From:
To: [DCAdmin](#)
Subject: 2023/91797
Date: 02 August 2023 16:50:44

**5, Jessop-View, Staincliffe, Batley, WF17 7SG
Erection of detached garage and shed**

PROPOSED SITE PLAN 1:200

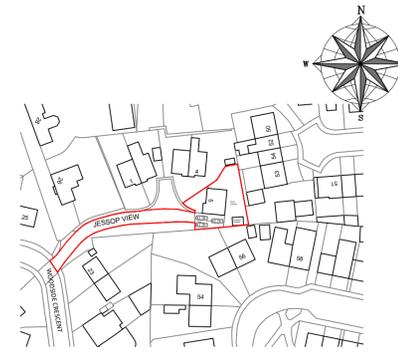
Jessop View Group of houses consist of a total of five separately built cul-de-sac houses, which have specifically delineated green areas and metalled approaches, with a common, open and shared communal space for manoeuvring of persons and vehicles. The status of this communal space and usage must be clearly maintained.

Since the applicant intends to make alterations inside at the back of his house, with pre-existing approach, passage and usage for the cul-de-sac, *this redlines elaboration is misleading and incorrect, and may be removed.
